A12 Chelmsford to A120 widening scheme

8.15 Statement of Common Ground with Boreham Parish Council

Statement of Common Ground with Boreham Parish Council

Version	Date	Status of Version
P01.1	February 2023	Draft

Drawing Title							
ENVIRONMENTAL STATEMENT ADDITIONAL NOISE MITIGATION SHEET 3 OF 5							
Drawing Status							
S4 – SUITABLE FOR STAGE APPROVAL							
Scale @ A3		1:20000			DO NOT SCALE		
Jacobs No.		B36601D1					
Client No.		HE551497			Rev P01

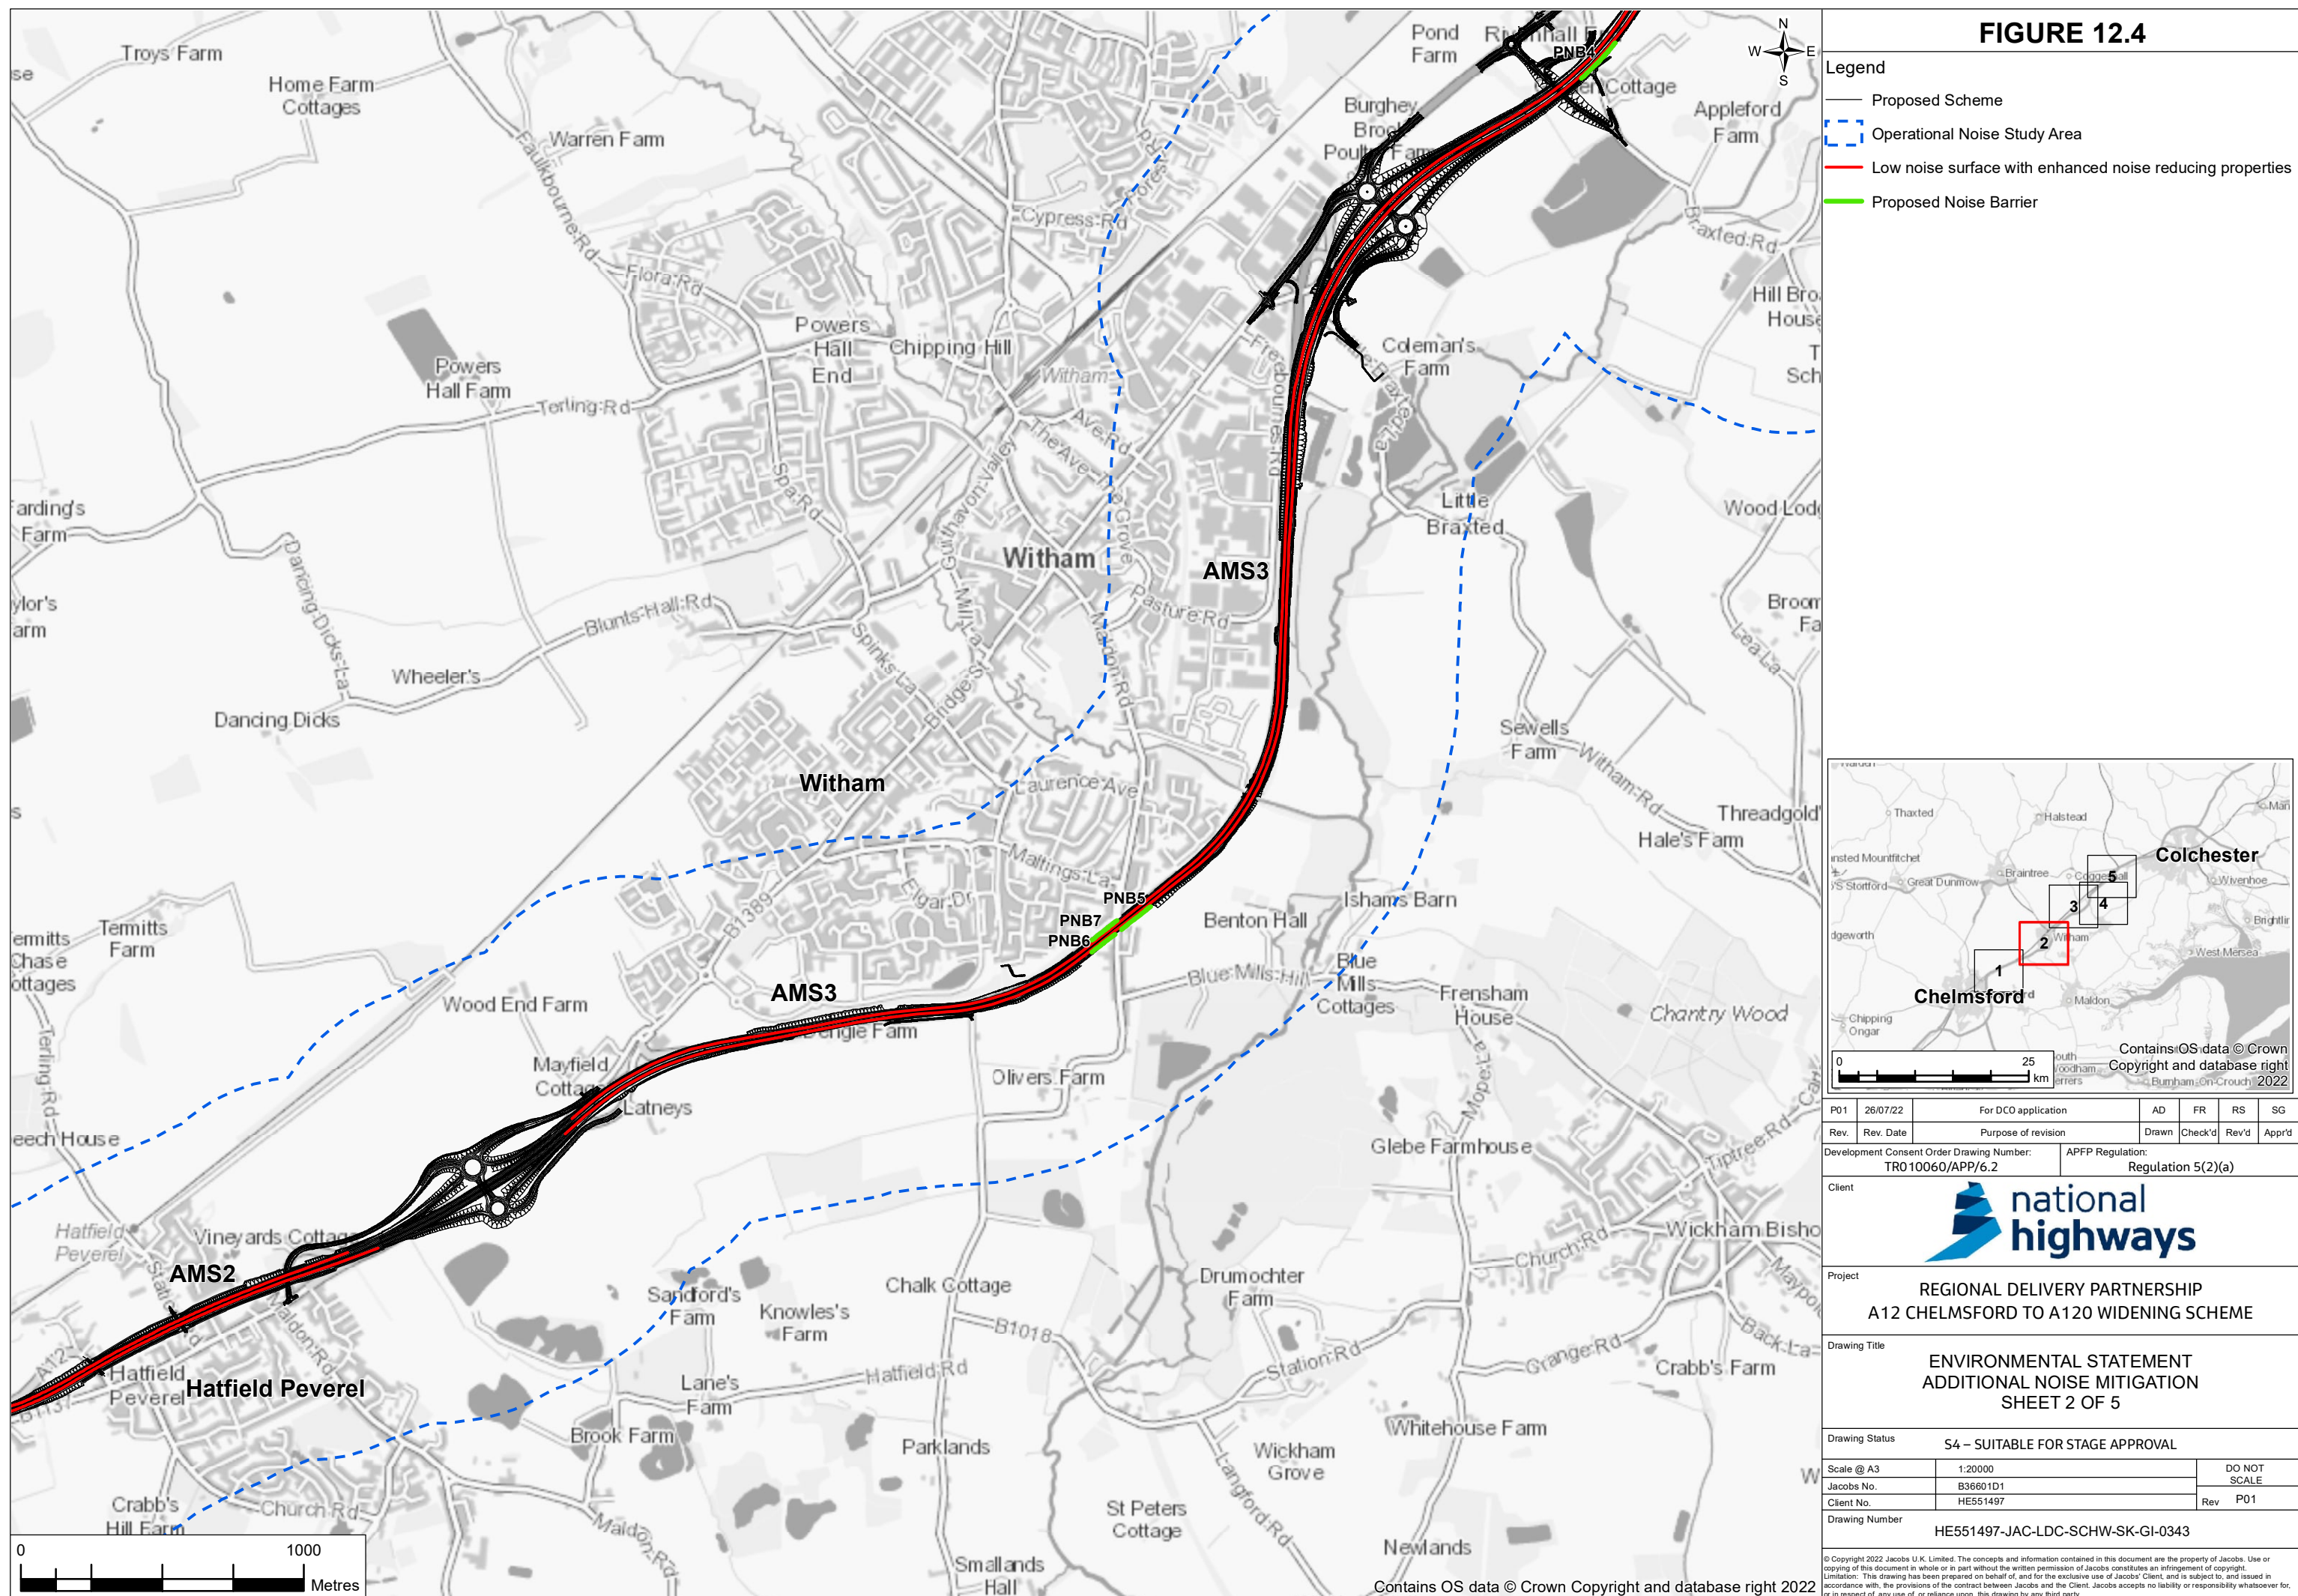
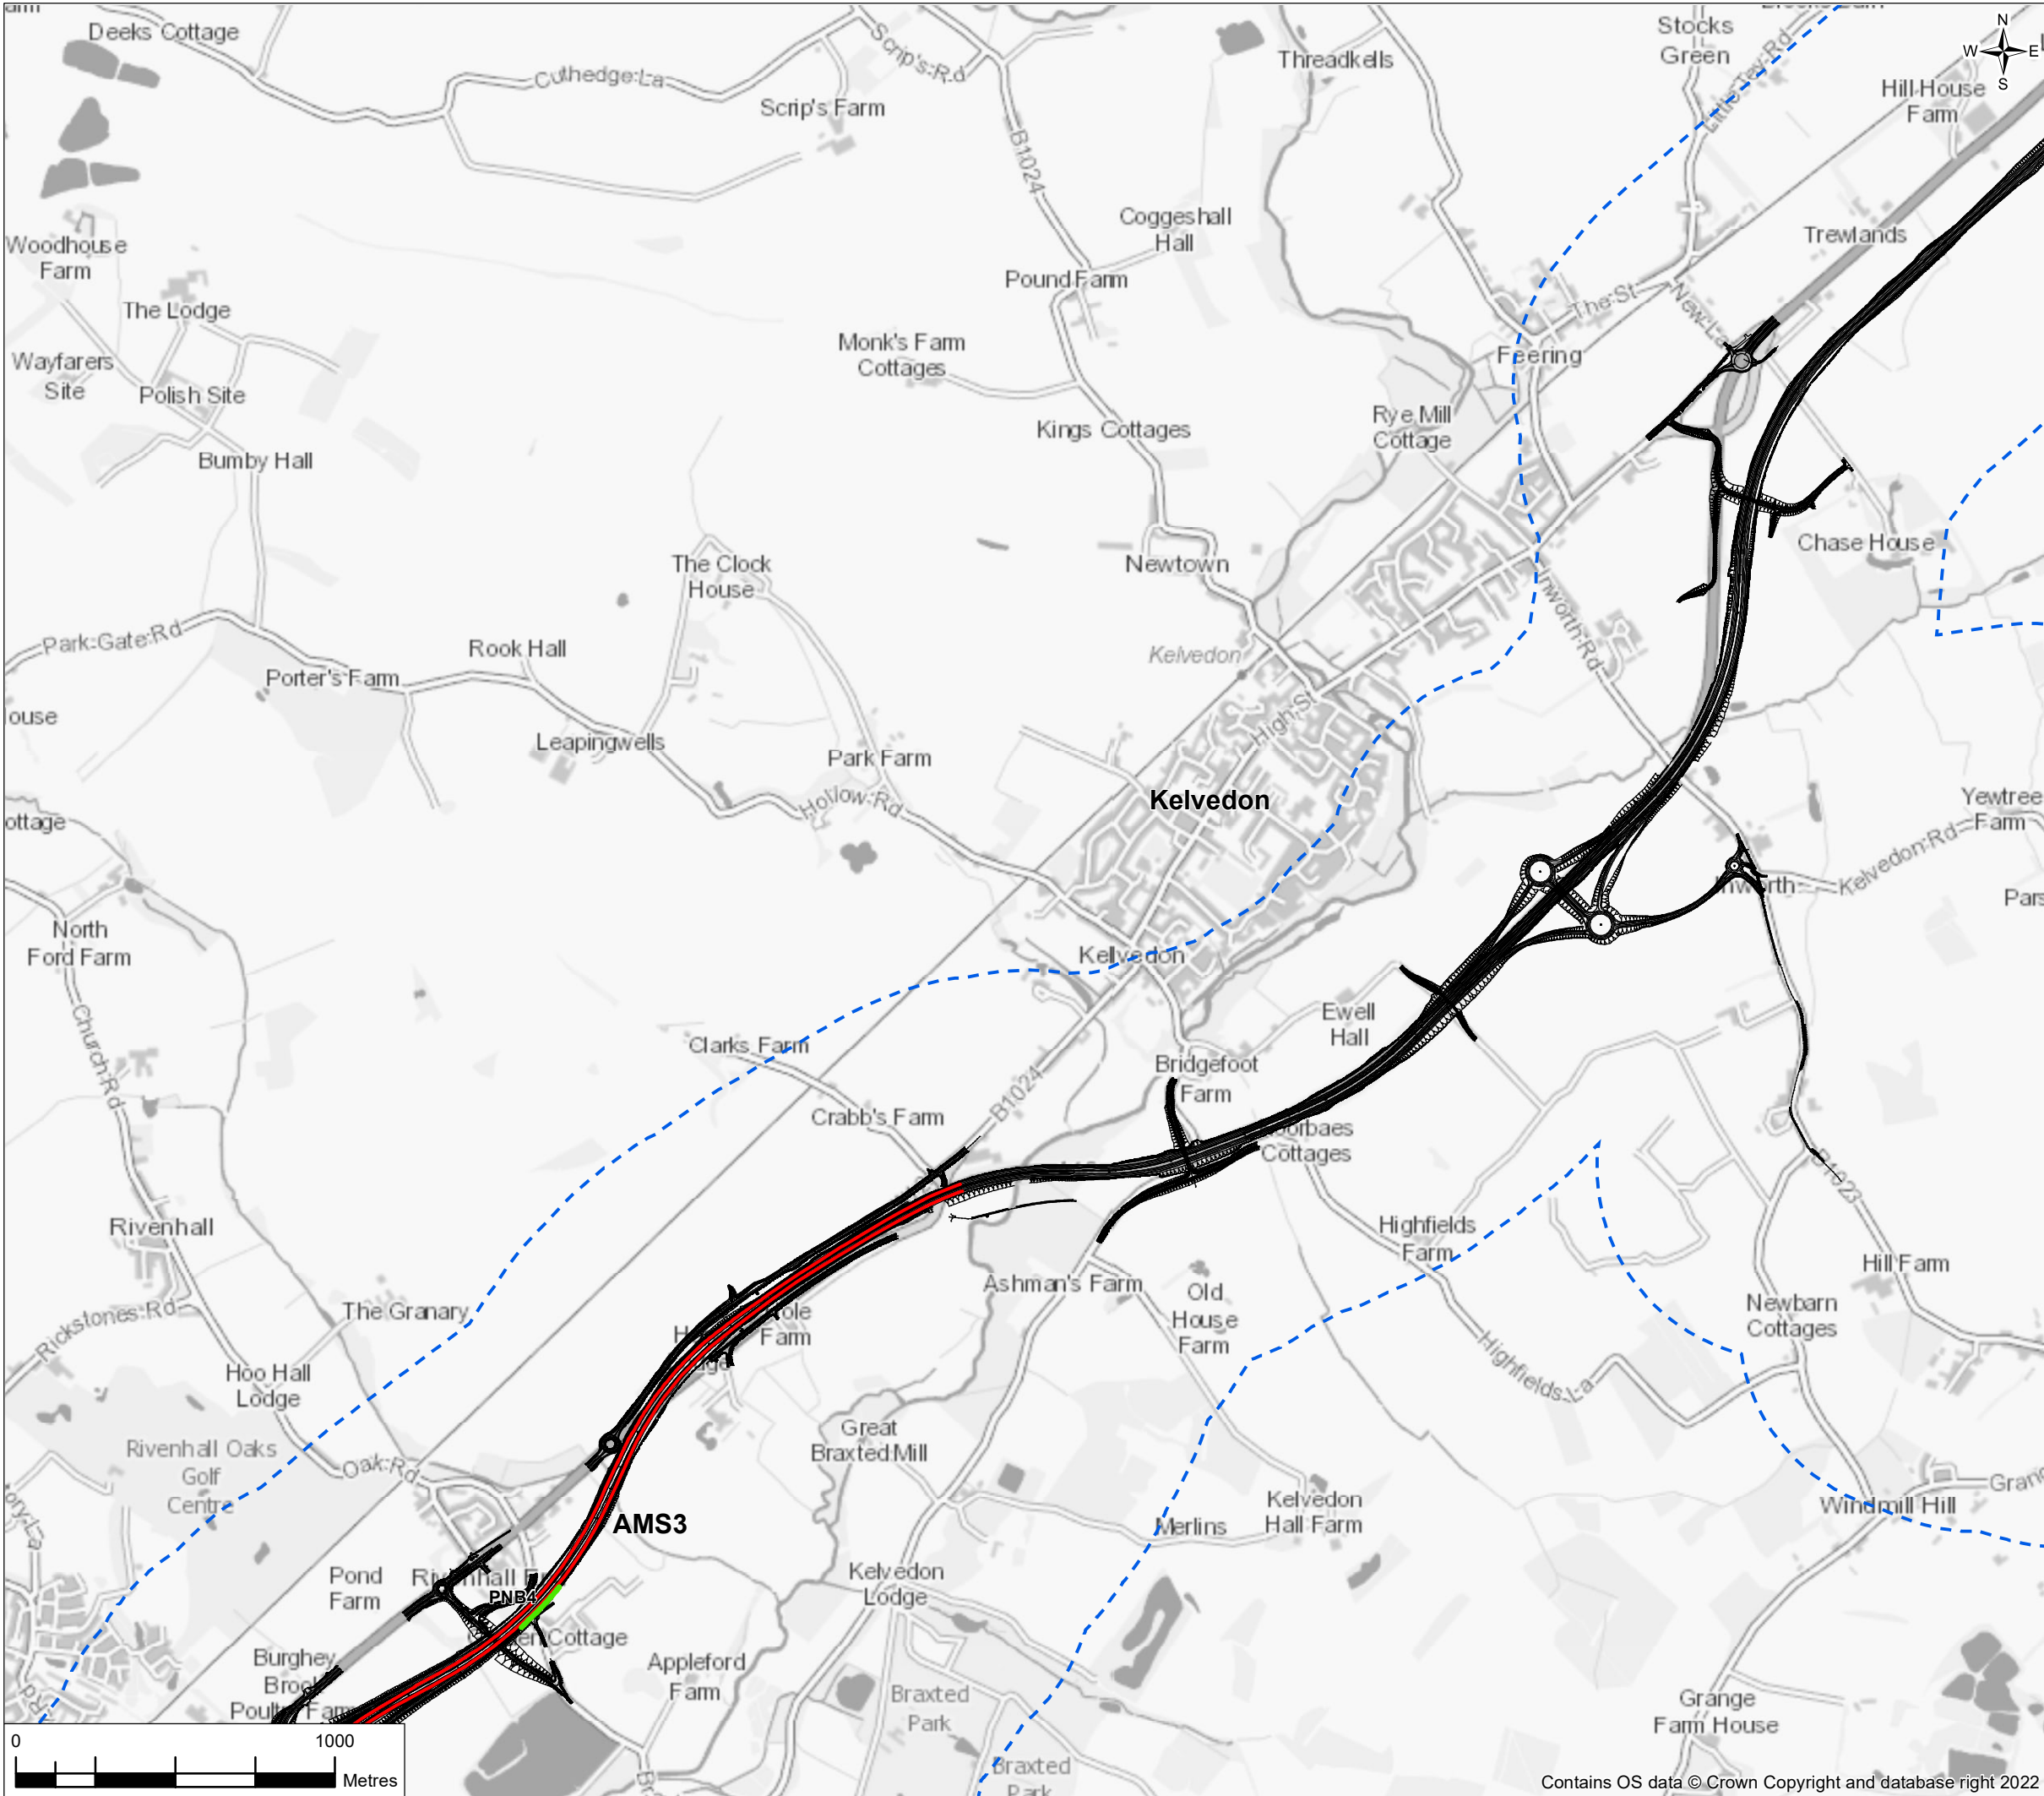
1.2	Noise reducing surfacing		We also ask that the developer reconsiders the decision not to use a noise reducing surface on both carriageways of the A12 as it passes through Boreham. This would benefit houses close to the road by mitigating the additional noise pollution resulting from the A12 widening	<p>Without mitigation, significant adverse effects were identified at 222 dwellings alongside the A12 at Boreham. These significant adverse effects were primarily caused by a predicted increase in traffic speed on the A12, but also an increase in vehicle flow. The increases in noise at dwellings were between 1 and 1.2 dB(A), but with the absolute noise being above the Significant Observed Adverse Effect Level (SOAEL), these were deemed likely significant adverse effects in accordance with Table 3.60 of DMRB LA 111.</p> <p>When significant effects are identified, the first mitigation measures examined are to reduce the noise at source. The path of the noise is then next considered, followed by measures at the receiver. This mitigation hierarchy is described in paragraphs 12.10.1 to 12.10.4 of Chapter 12: Noise and vibration-, of</p>	Under discussion	06/02/2023

Ref	Issue	Doc Reference	Boreham Parish Council Position	National Highways Position	Status	Date
				<p>the Environmental Statement [APP-079].</p> <p>Removing the significant adverse effects through surfacing was therefore considered first. The surface of the A12 alongside Boreham is already a low noise surface, and so following the guidelines in DMRB LA 111 for noise modelling, no benefit in noise terms could be gained through re-surfacing with a conventional low noise surface. Using a surface with better noise reducing properties than a conventional low noise surface was therefore considered. Re-surfacing just one carriageway was first examined in order to retain as much of the relatively new existing surface as possible, and this was found to be sufficient to remove the significant adverse effect at the dwellings, with changes in noise varying between negligible increase and negligible decreases (+/- 0 – 1dB(A)) with the surface with better noise reducing properties than a conventional low noise surface in place on one carriageway. Since this is predicted to</p>

Ref	Issue	Doc Reference	Boreham Parish Council Position	National Highways Position	Status	Date
				<p>reduce the noise level to the level it would be without the scheme, this option was therefore taken forward by the Applicant.</p> <p>The provision of the surface with better noise reducing properties than a conventional low noise surface on both carriageways would deliver minor reductions in noise of between 1.8 and 2 dB(A) at those dwellings alongside the A12. Therefore, the provision of the surface on both carriageways would deliver a minor benefit (which is classed as a noise reduction between 1.0 to 2.9 dB(A)) compared with the identified mitigation which would have delivered negligible changes in noise. With the identified mitigation, all of the identified significant adverse effects would be removed, and this would be the same if both carriageways were resurfaced. The scheme would therefore meet the first aim of paragraph 5.195 within the National Networks -National Policy Statement by avoiding significant adverse impacts on health and quality of life</p>
